# PLANNING CONSULTATION REPLY

**APPLICATION: Pinder Oak Cygnet Health Care, Upper Sheffield Road, Barnsley, S70 4PT.**

**2 0 2 3      0 0 7 4**

Photographic plate showing the beech tree - 1882.

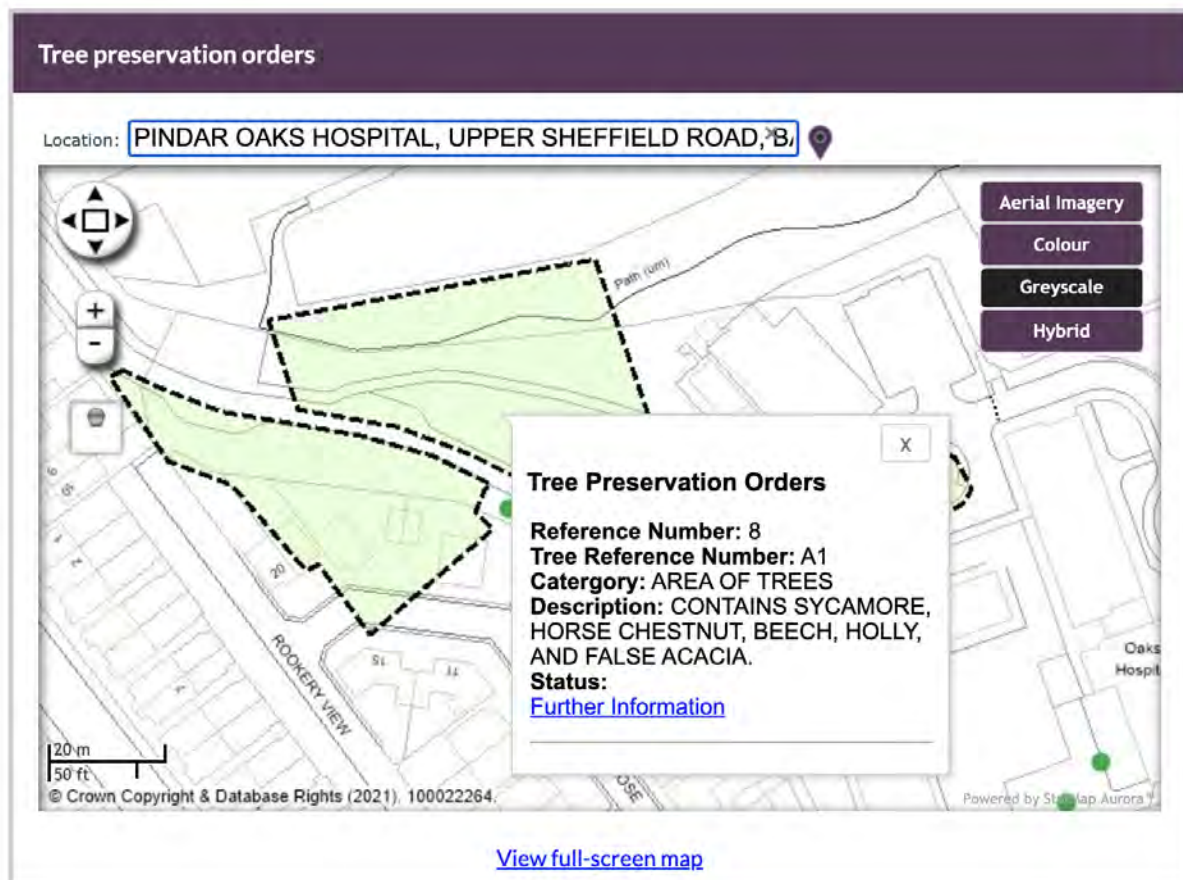
The tree is a large mature highly prominent specimens located along the access road to Pinder Oak Cygnet Health Care, as such has high amenity value. The works proposed are to remove branches marked in photograph from Beech tree T1882.

The works proposed will act to maintain clearance from the neighbouring property through the removal of several small branches as noted on the submitted photo. The works are relatively minor and will not be of detriment to the tree and as such there is no objection to the proposal from an arboricultural perspective.

The above works are approved subject to the following conditions

Not less than five working days notice of the date of the proposed work shall be given in writing to the Local Planning Authority and the tree surgery shall be carried out to the standards set out in BS3998.
